From: Patel, Uday [Uday.Patel@lancashire.gov.uk]
Sent: 22 February 2013 13:41
To: planning
Cc: Claire Booth
Subject: 03 /2013/0046 - Demolition of external garage and construction of one residential bungalow - 54 Whalley Road Sabden Lancashire BB7 9DZ

Planning Application Reference: 03 /2013/0046
Proposal: Demolition of external garage and construction of one residential bungalow
Location: 54 Whalley Road Sabden Lancashire BB7 9DZ

Uday Patel
Developer Support
(Environment Directorate - Lancashire Highway Services)

Proposed Site Plan 1:200

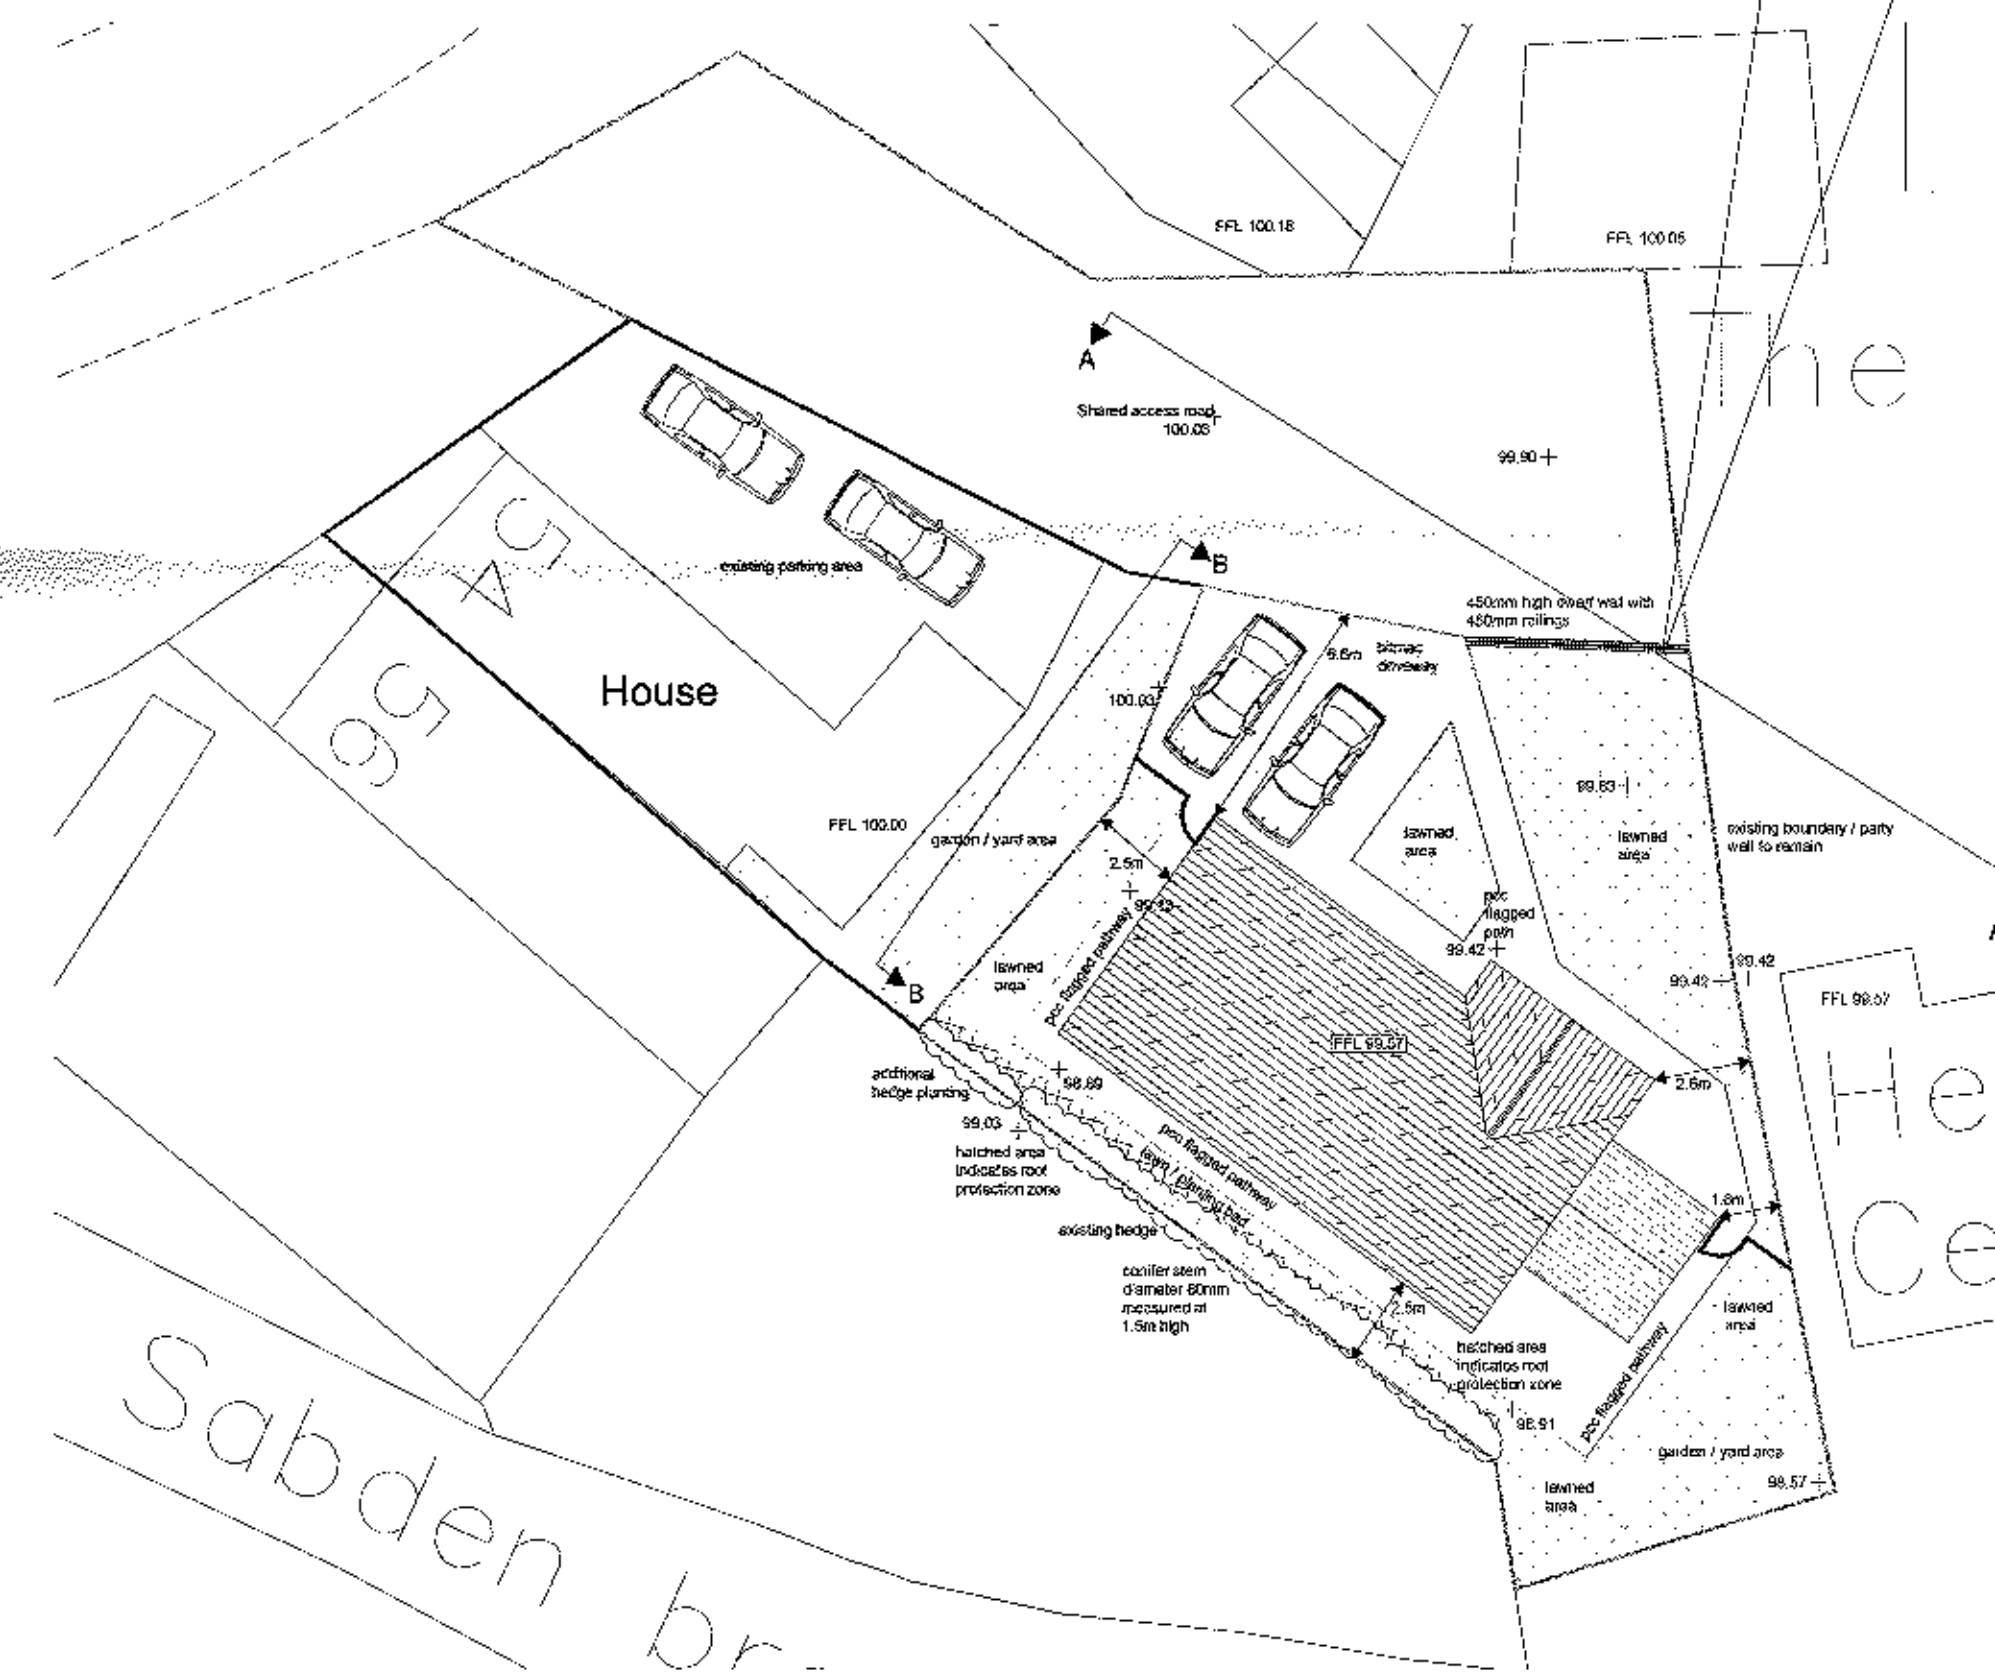
The proposed development is to demolish the existing garage building and erect 3 bed room detached dwelling. According to JLSP parking standards, 3 bed room dwelling will require 2 no parking spaces. The proposed layout indicates one integral garage as well as one parking space in the fore court area within the curtilage of the property. The access to the proposed development is from Whalley Road which is a 30mph distributor road. Visibility measured 2.4m from behind the existing kerb line of Whalley Road along the centre line of existing access is more than 50m in each direction along Whalley Road. Visibility is considered appropriate with regard to the speed of the road.

There shall be appropriate turning radius/area within the curtilage of the property which allows the vehicles to exit the property in forward gear position. Reason: To consider public safety. To this extant there may be need of amending the layout accordingly to include this situation.
